WEST SUSSEX COUNTY COUNCIL CONSULTATION

TO:	<u>Arun</u> District Council <u>FAO:</u> Michael Eastham
FROM:	<u>WSCC</u> - Highways Authority: Tim Townsend
DATE:	27 March 2020
LOCATION:	Land to the south of Ford Lane and east of North End Road <u>Yapton BN18 0DS</u>
SUBJECT:	<u>Y/19/20/RES</u> Approval of reserved matters following outline consent Y/80/16/OUT for 4.5ha of residential development comprising of 3.4ha of land for the erection of 100 No. dwellings (up to 30 (30%) affordable housing) together with 1.1ha of land set aside for public open space & strategic landscaping & 2.2ha of public open space & green corridors with vehicular access from Ford Lane & pedestrian/cycle access only from North End Road. This application may affect the setting of listed buildings, affects the character & appearance of the Church Lane, Yapton Conservation Area & affects a Public Right of Way. Further information received.
DATE OF SITE VISIT:	<u>n/a</u> for purposes of this RES application (visited at outline stage)

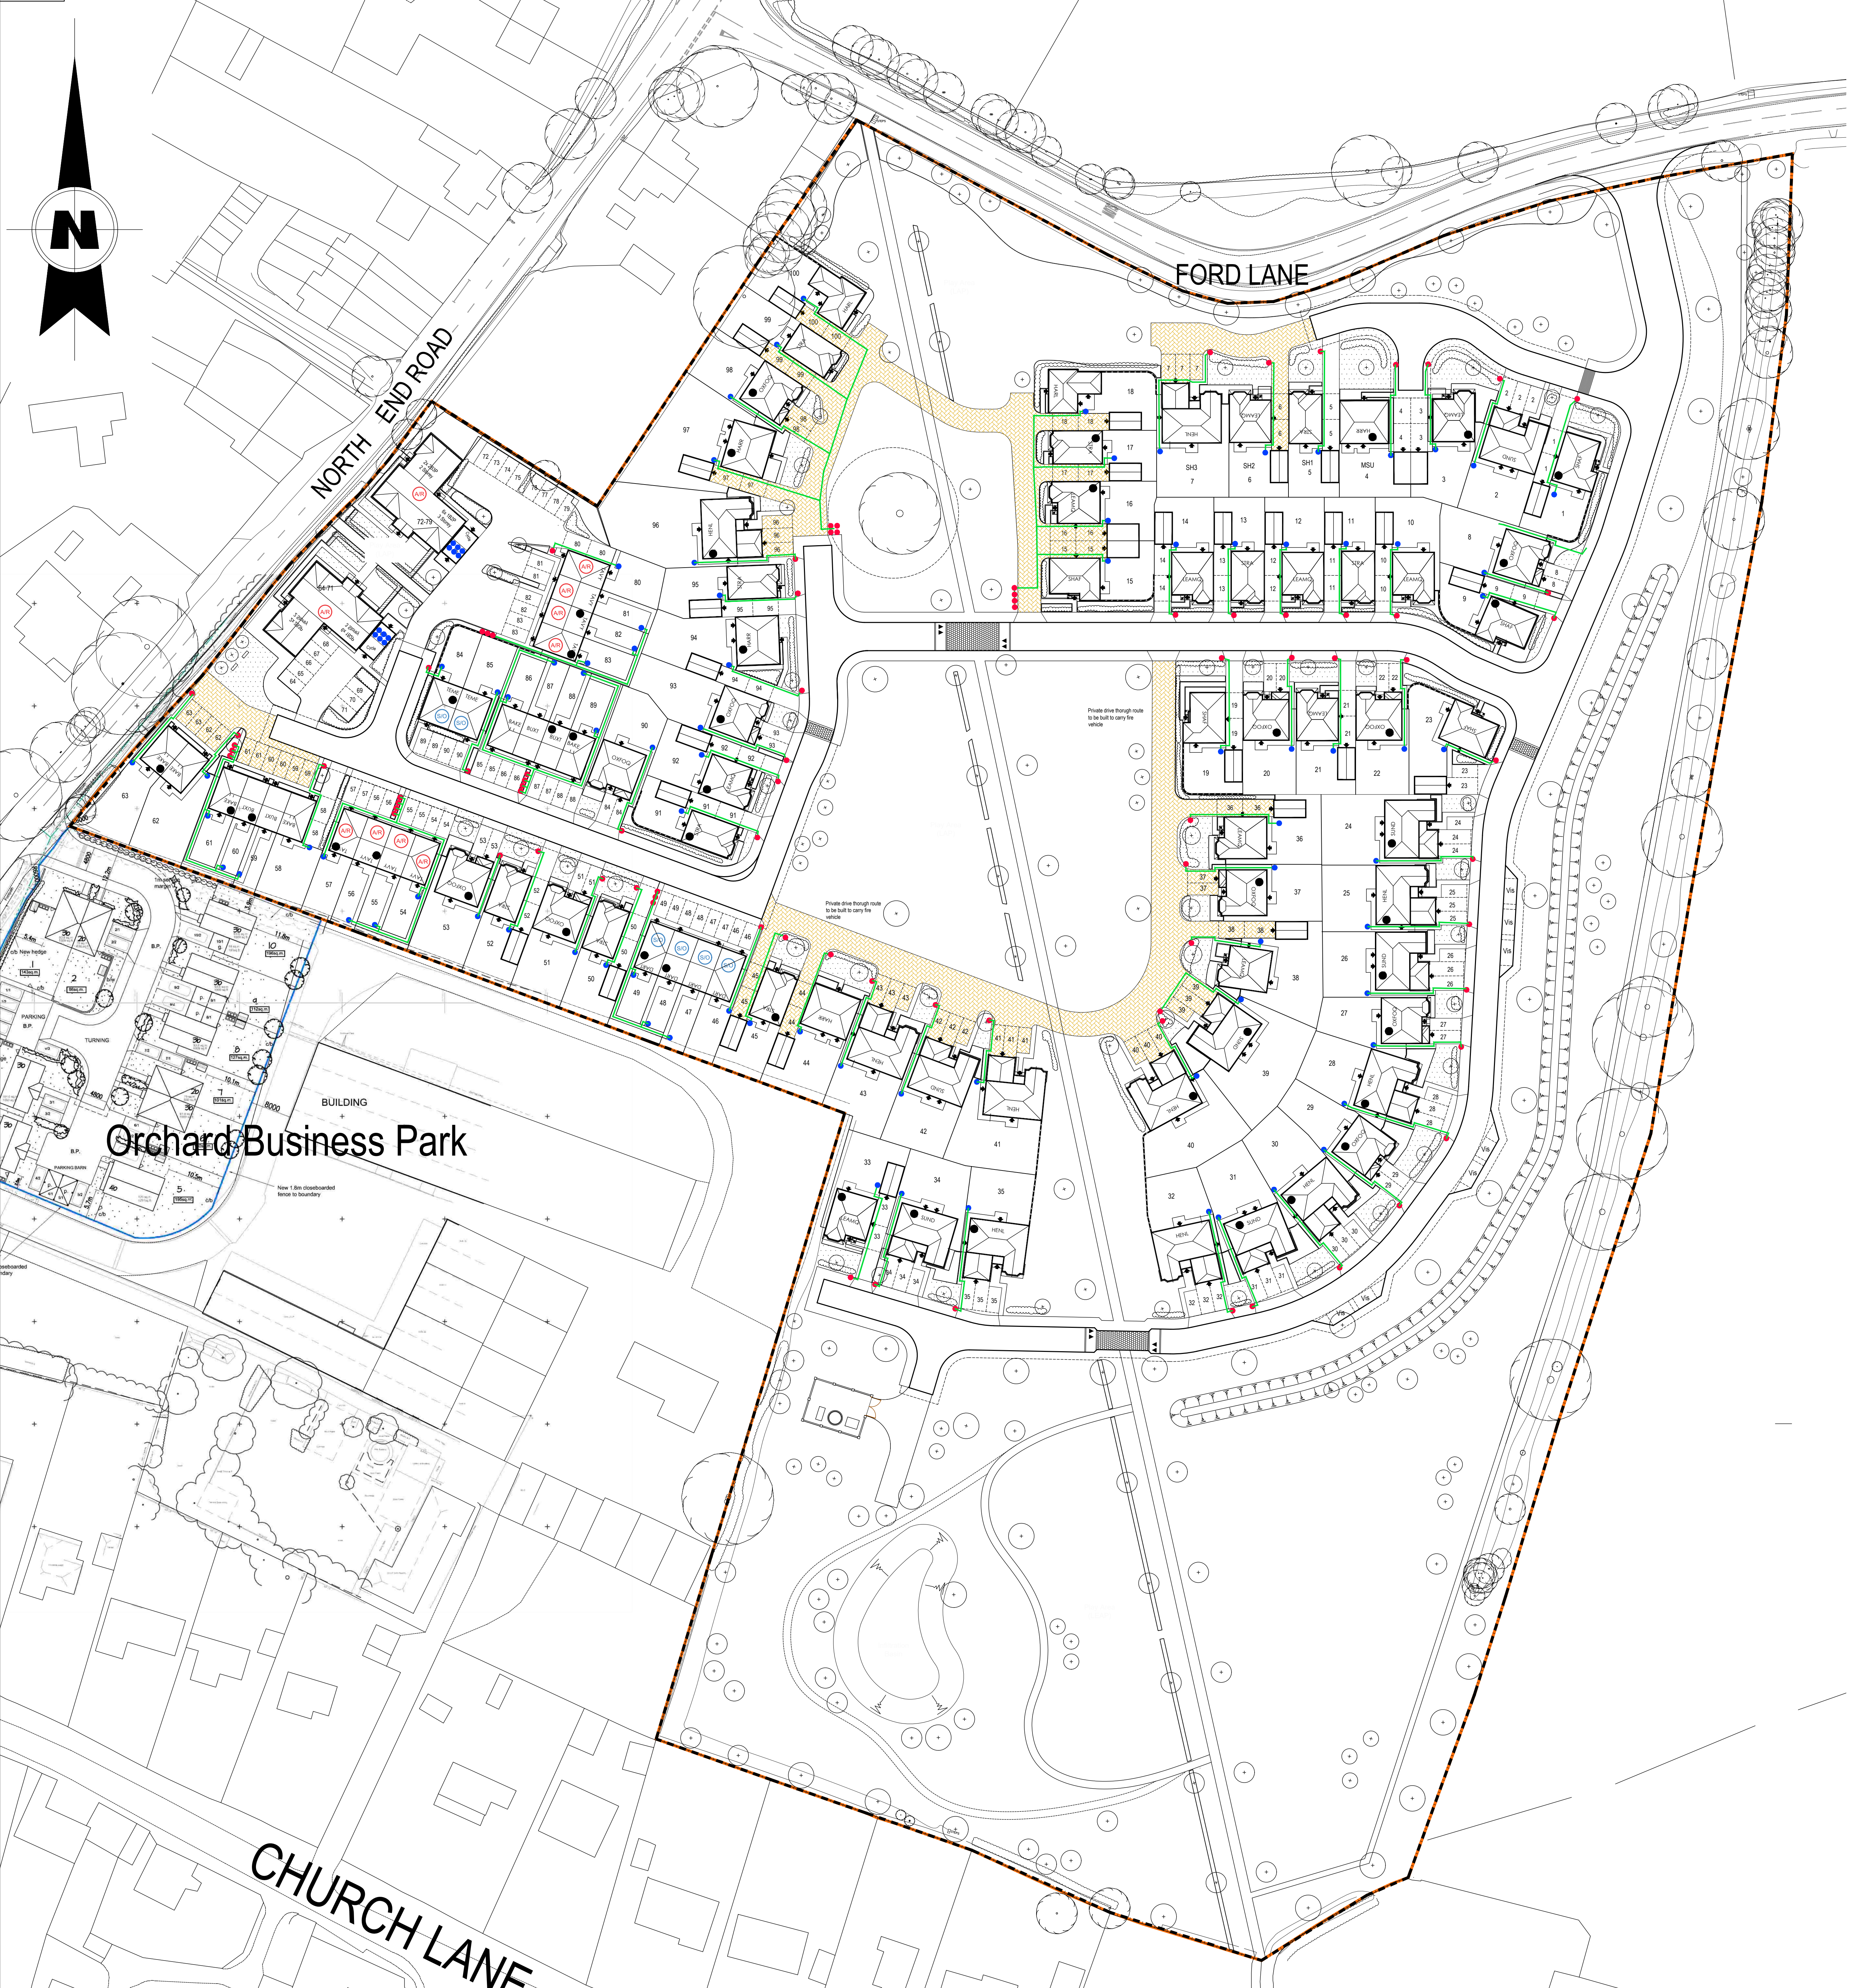
- 3. Access for emergency vehicles and refuse vehicles** – This is shown on Odyssey drawings 18-344/100 and 18-344/101 – both revision 'A'.
- 4. Parking provision (including cycle and visitor parking)** – *Car parking* - Parking space and garage space dimensions all appears to follow advice contained in Manual for Streets. With regard to numbers of spaces and how they are allocated throughout the development, Arun District Council parking guidance should now be followed. However as an observation, visitor parking does appear to be under-represented throughout the majority of the scheme. As such, it is recommended that the applicant re-appraise this. With regard to the visitor spaces shown on the eastern-most access road (opposite plots 26 and 31), 1.2m wide hard strips should be added to the rear of them to assist with entering and leaving vehicles.

Private Parking (199 spaces)

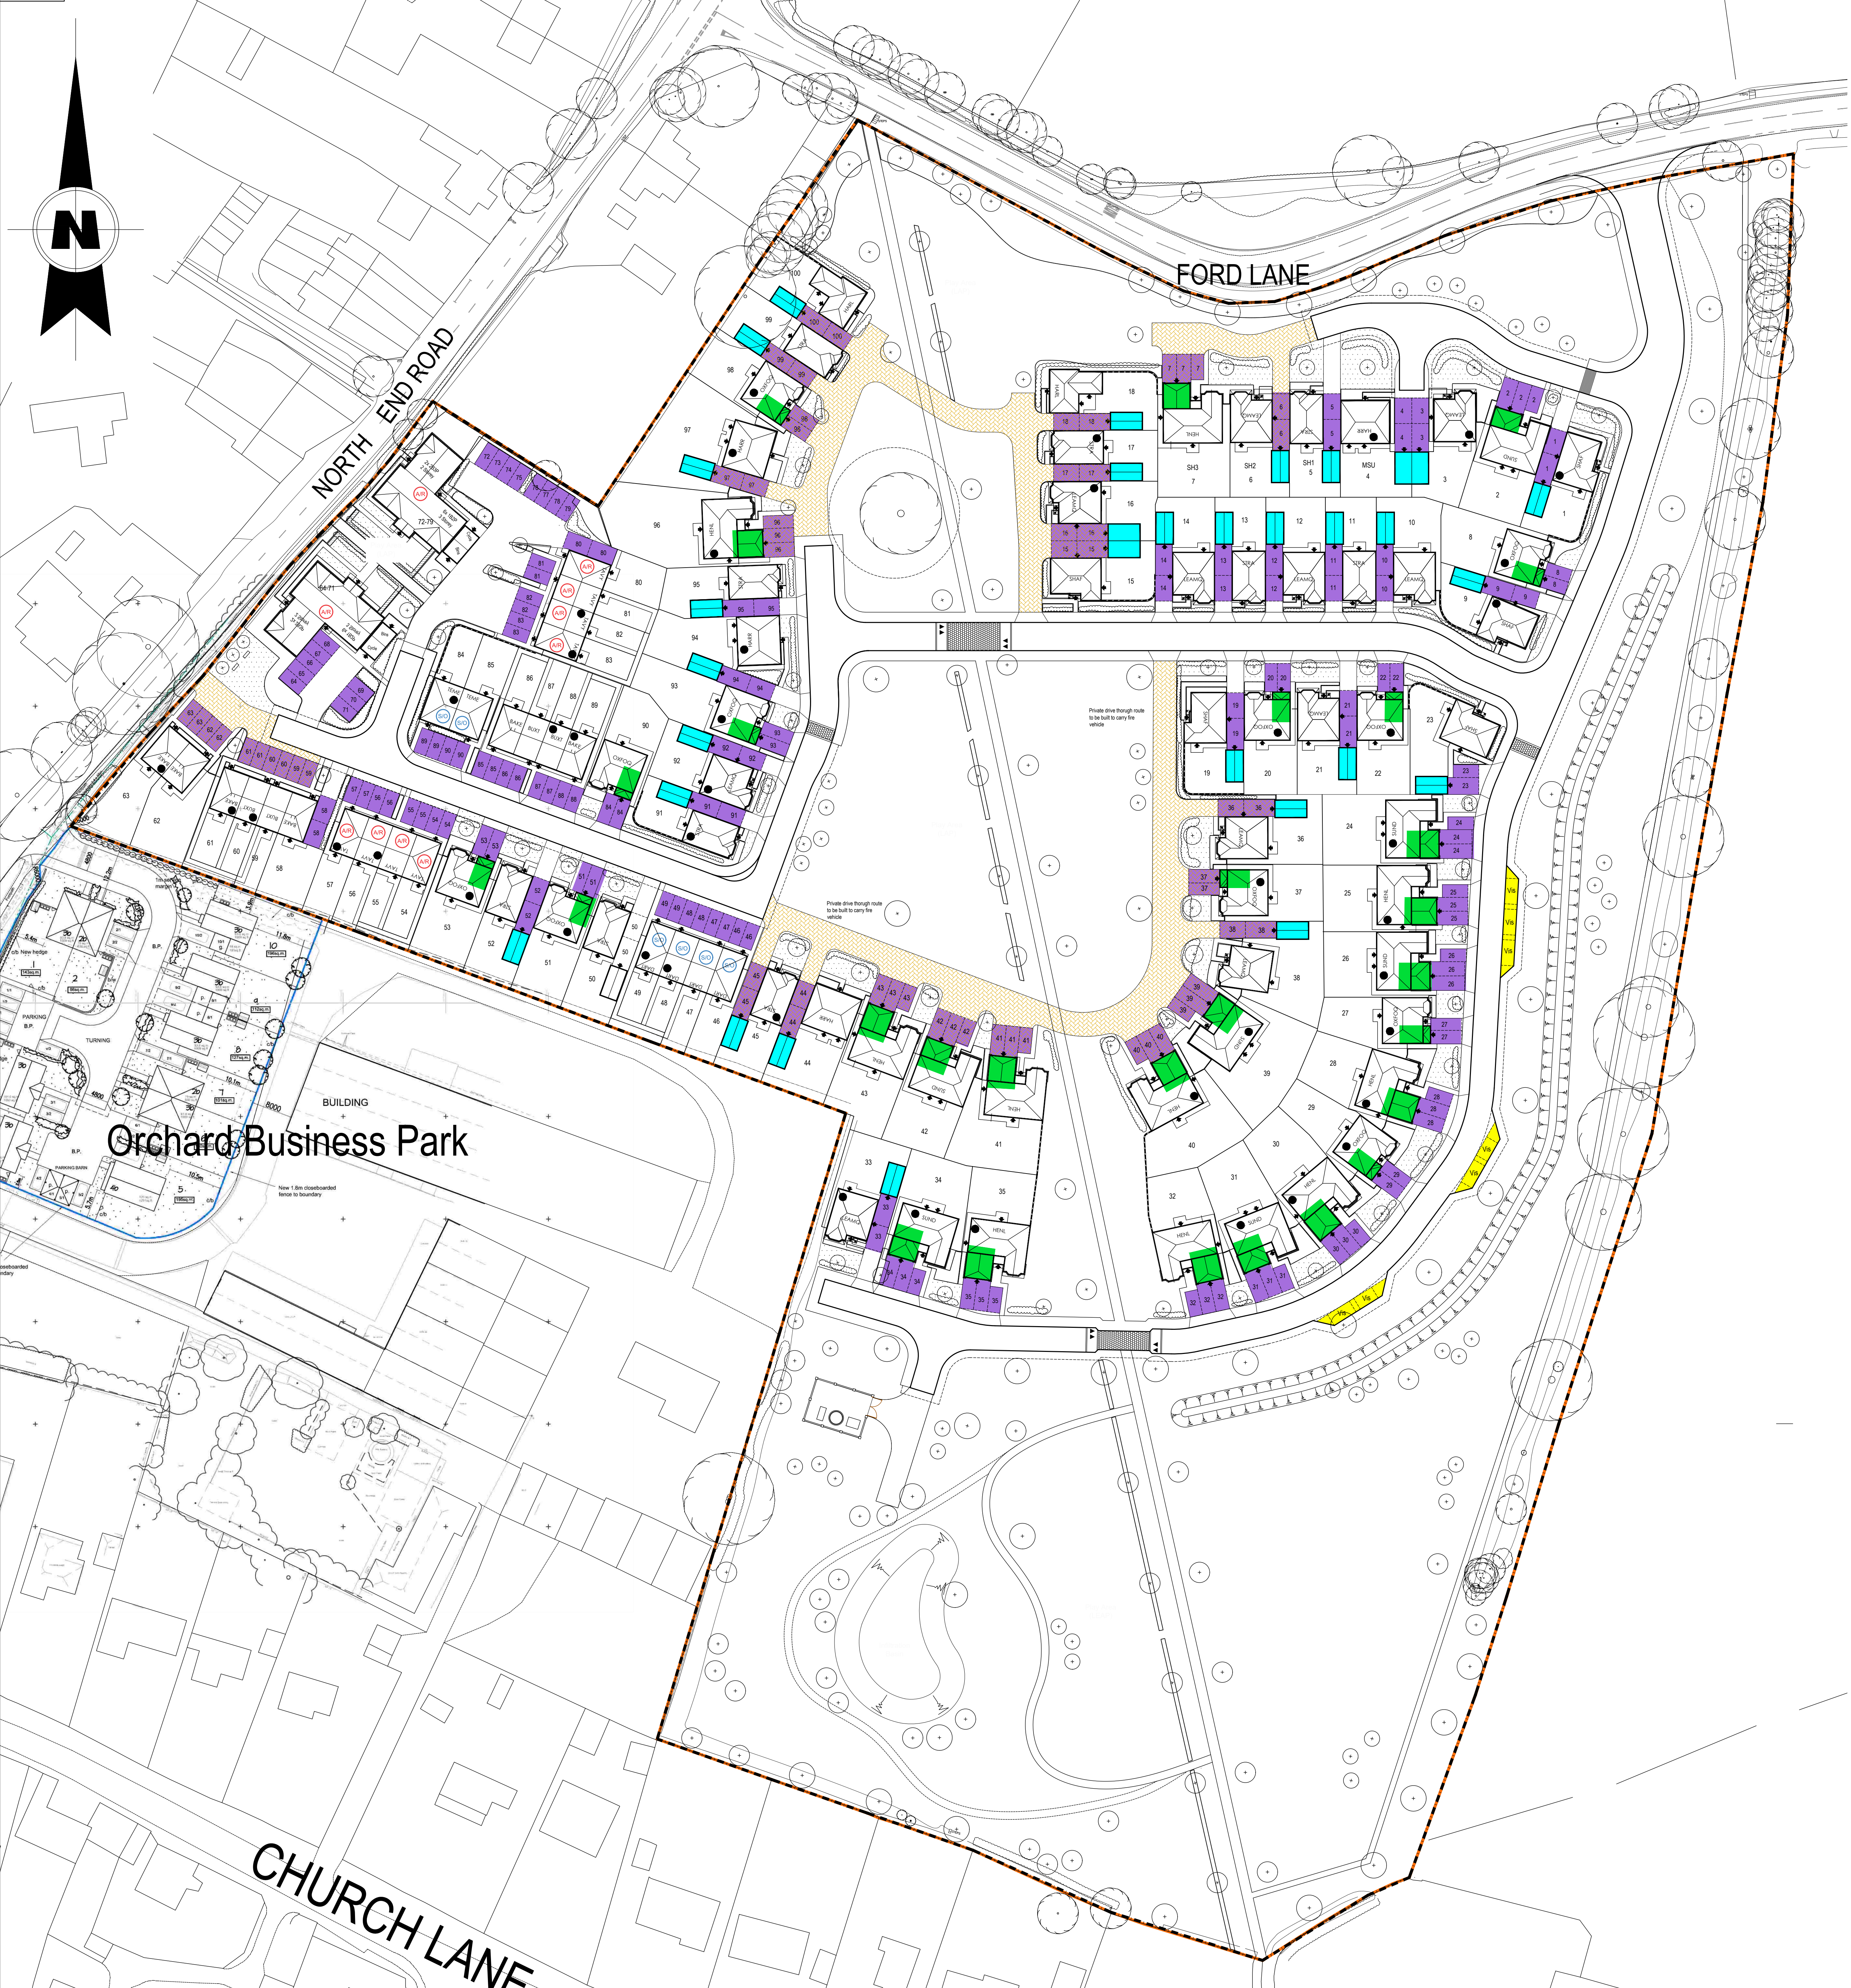
Cycle parking – Properties with garages would have space for cycles within based on the dimensions shown on the submitted planning application drawings. Also, the flats on the western-side of the site appear to have cycle stores (albeit with limited detail of the latter being available to view). However, it is not apparent from looking at the plans where cycle parking for all other properties would take place. Applicant to provide further detail for both the flats and the properties without garages, please.
